# CITY OF ALBUQUERQUE

**Re: Talavera Subdivision Drainage Management Plan  
Engineer's Stamp dated 1-7-09**

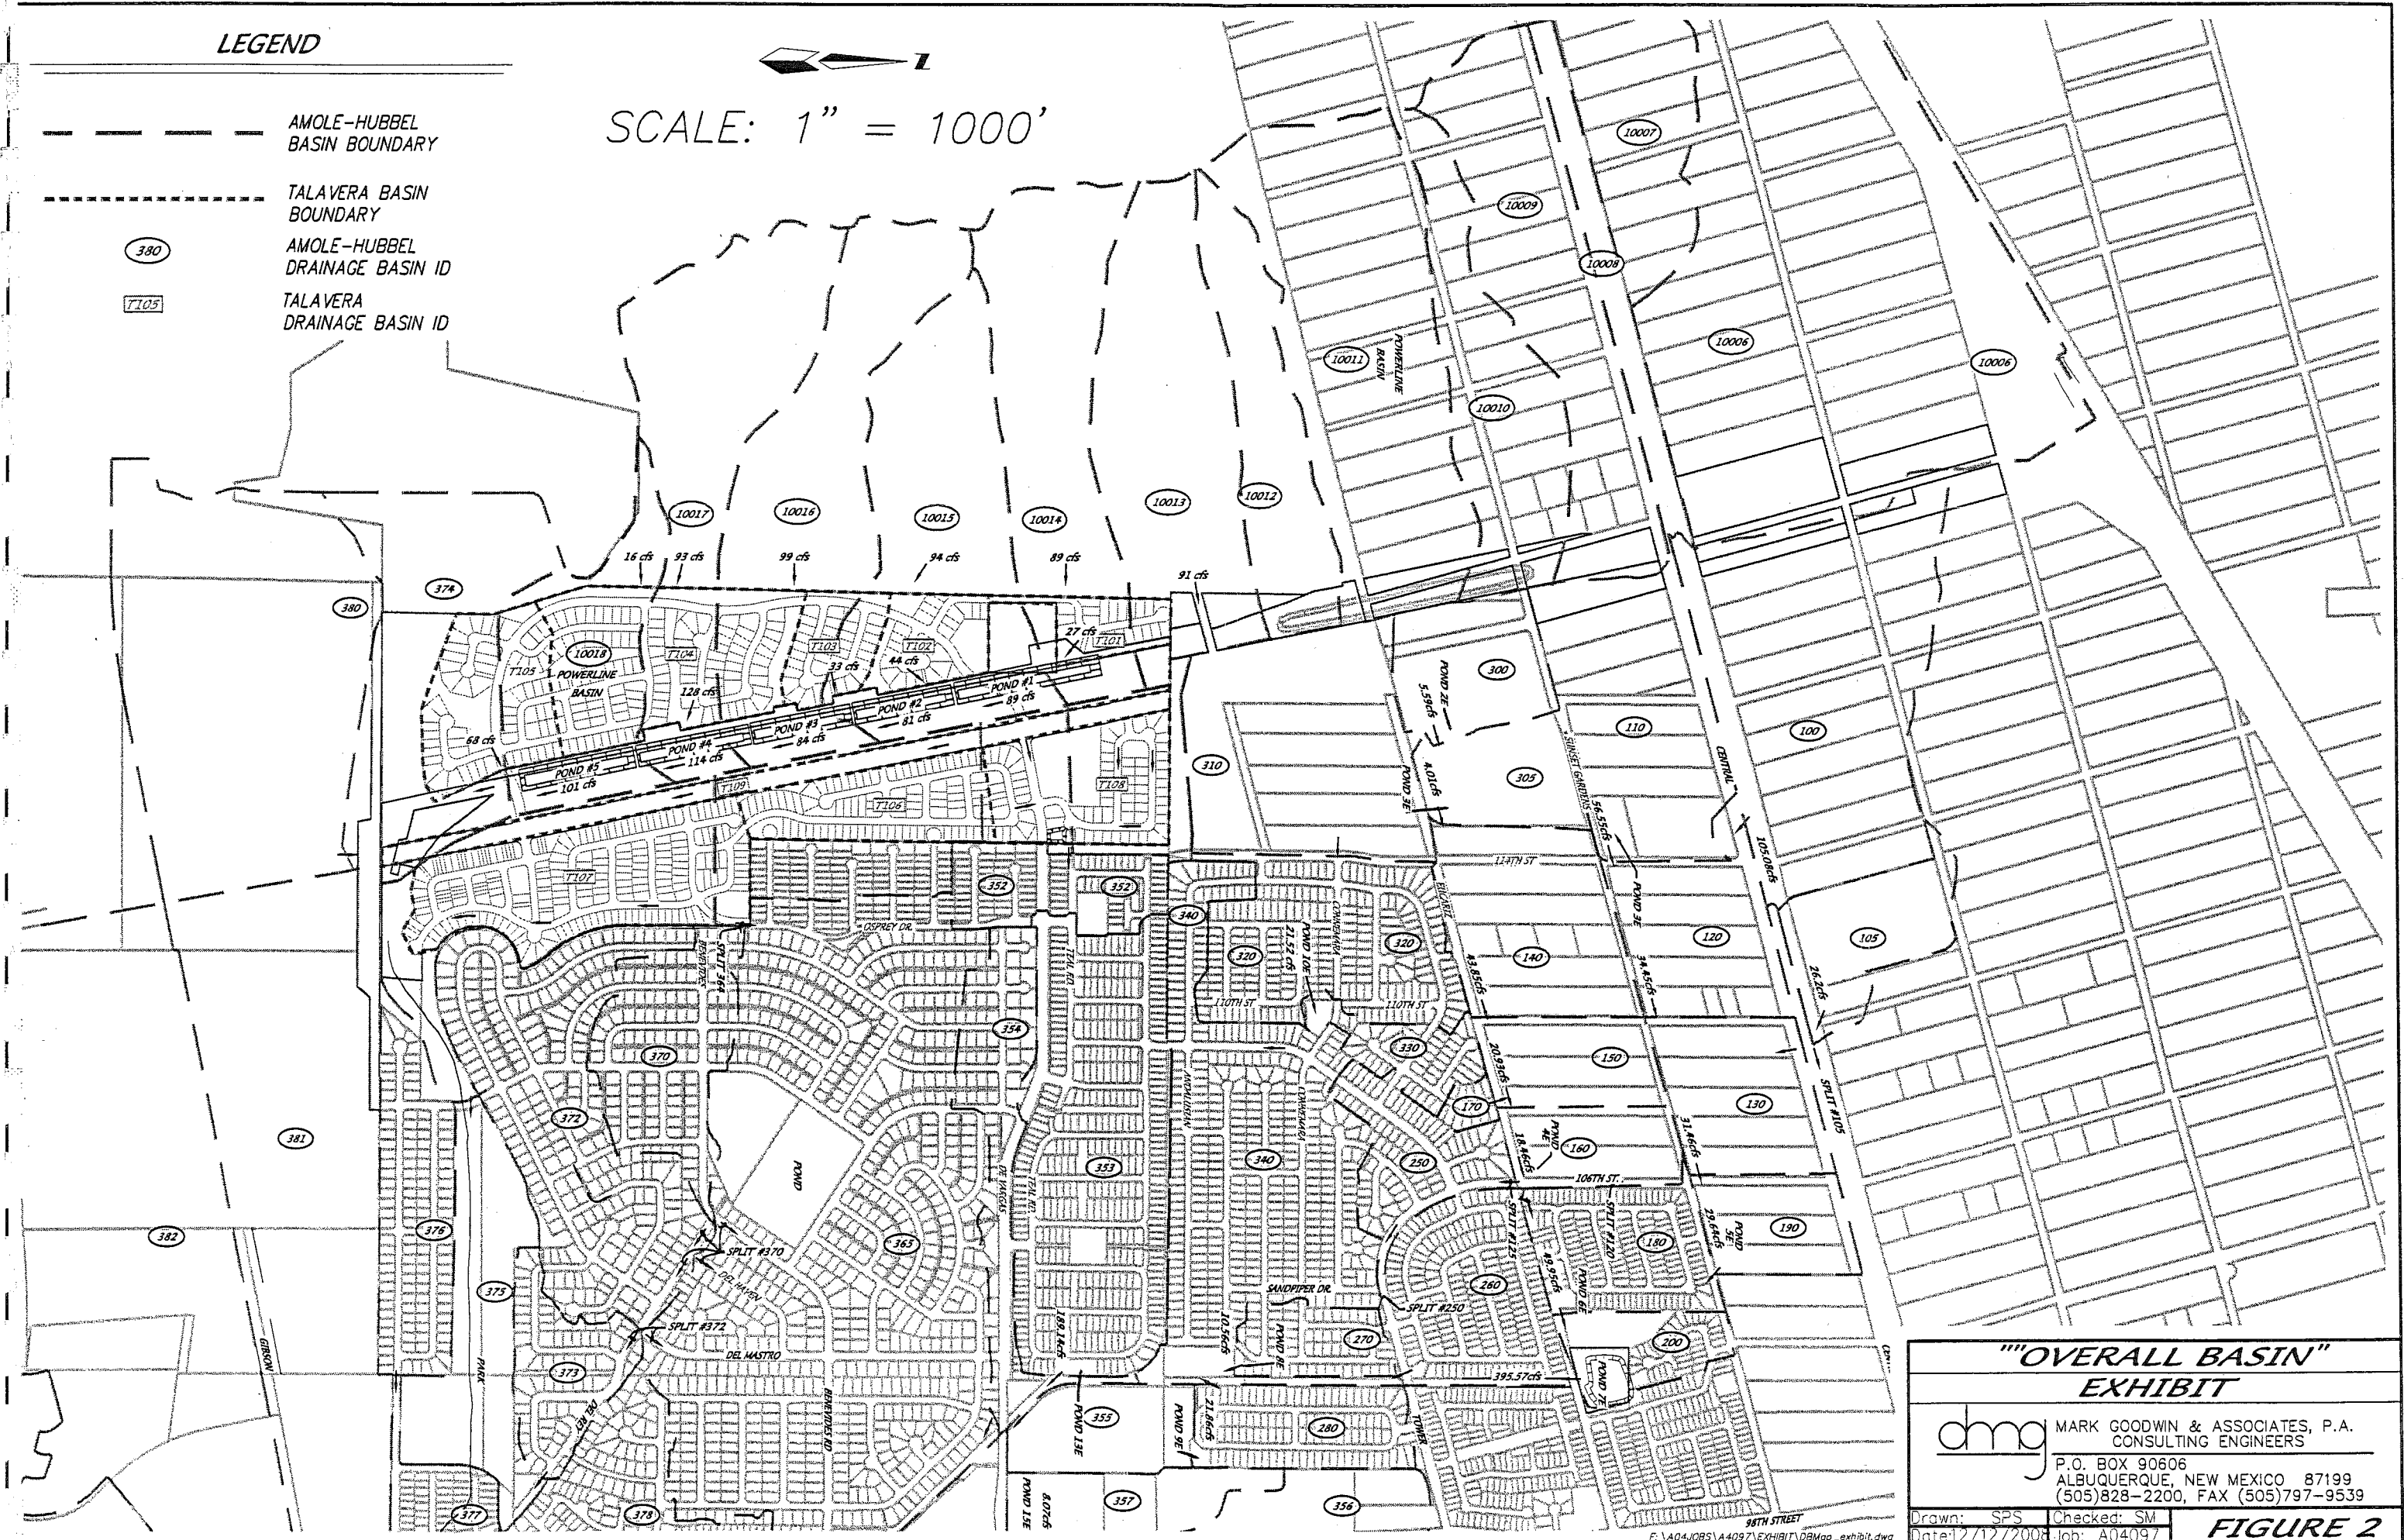
- In order to obtain public maintenance for pond #6, it would need to be 2 ac-ft in volume, minimum. Increasing the size would also alleviate the burden on the surge pond (12E) just downstream. Please consider that when the subdivisions within the Snow Vista basin are in design.
- Your basin map infers that all of 118<sup>th</sup> will drain into the Amole Arroyo. This would also infer that there will be a waterblock at all the roads connecting to 118<sup>th</sup> or that there will be enough storm drain to completely contain this basin. Looking at the topography of the area, it will be difficult to provide a waterblock at those intersections.
- Flows into Westgate subdivision should be kept to a minimum since there is a history of drainage problems on Benevides and any additional runoff entering this street may require some storm drain extension as part of your project.
